To:	DA Mattox
From:	Thomas Melville
Date:	March 27, 2018
Subject:	SAFEbuilt Permit Review – Design Team Comment Response

The purpose of the memorandum is to capture and provide response to SAFEbuilt Permit Drawing Review Comments for East Tower Expansion as received on March 23, 2018. Drawings are in the processes of being revised and are to be issued as Addendum No. 2 to direct the CM for revisions. Subsequent to this issuance, a full permit set will be issued to SAFEbuilt.

MMC EAST TOWER – BUILDING REVIEW

TITLE
CODE COMPLIANCE PLAN - LEVEL 6

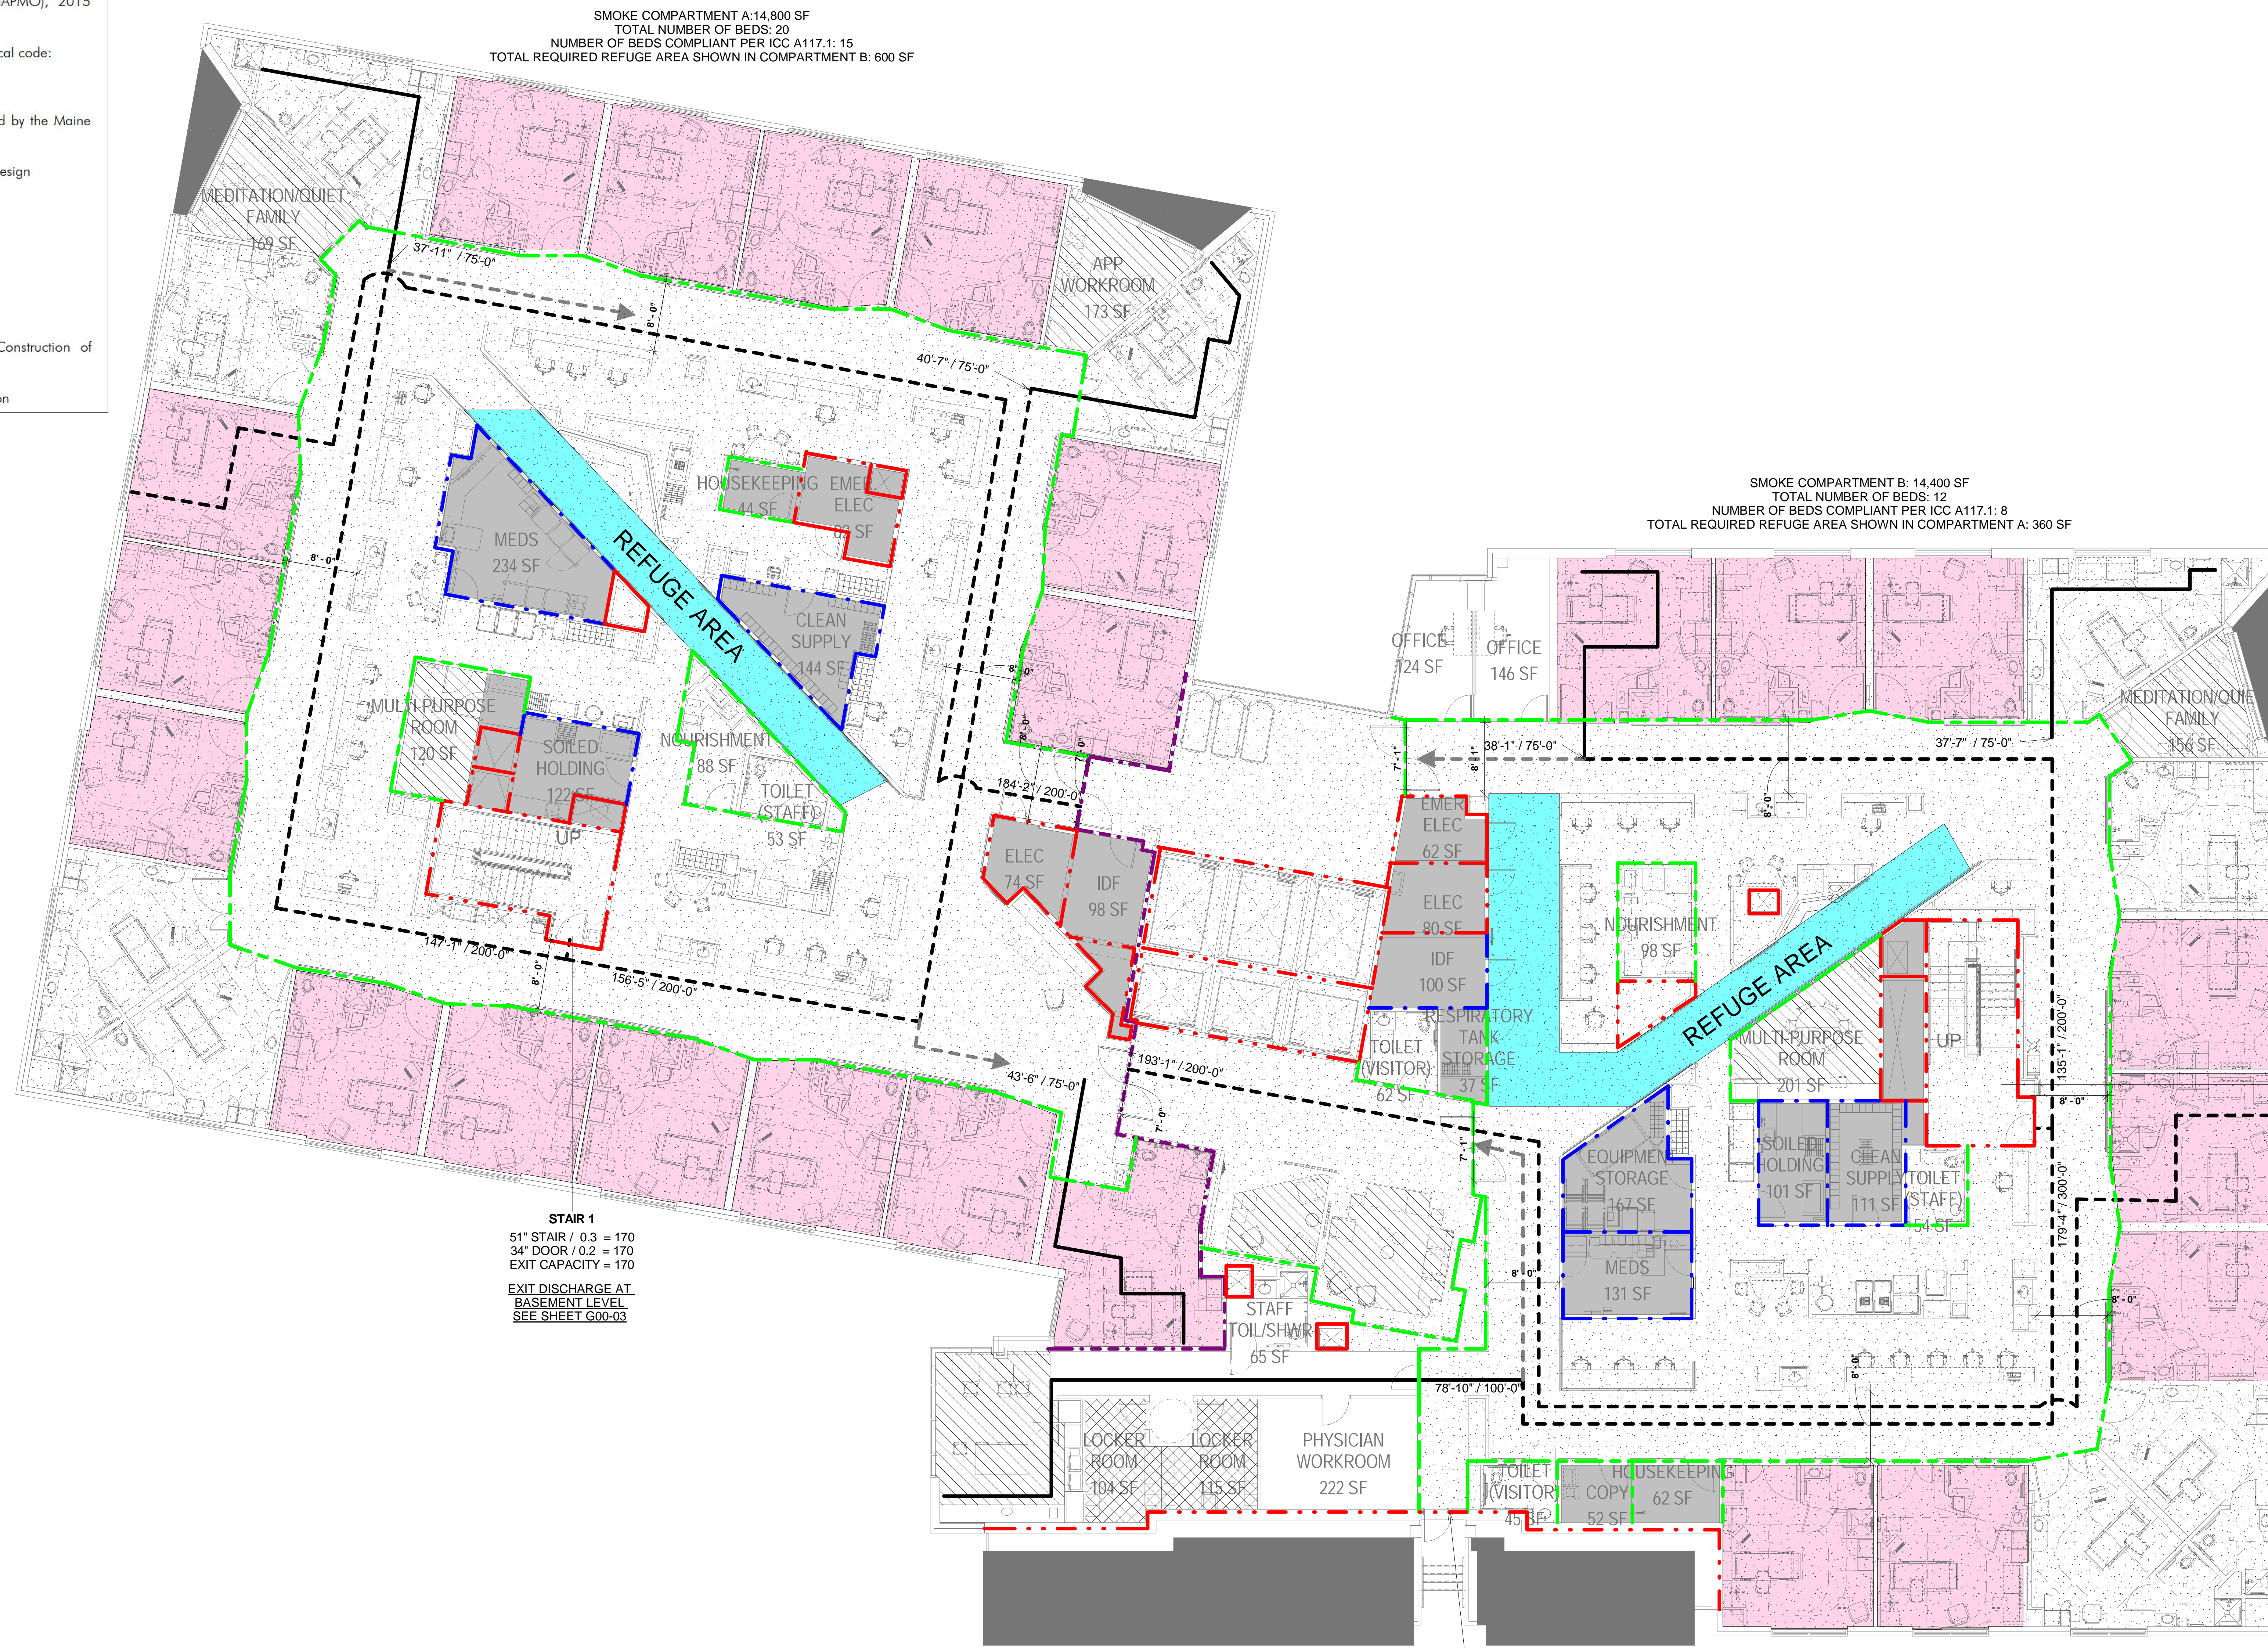
Plans appear to indicate, and reviewer assumes, that all patient toilet rooms are intended to be accessible in compliance with A117.1 section 1002. If this assumption is not accurate, a code summary should be provided indicating the number and type of units in accordance with IBC 1107.5.3. The following 3 comments are based on this assumption.

All Patient Toilet Rooms are not intended to be accessible. Number and types of accessible units will be indicated in accordance with IBC 1107.5.3 for Addendum No. 2.
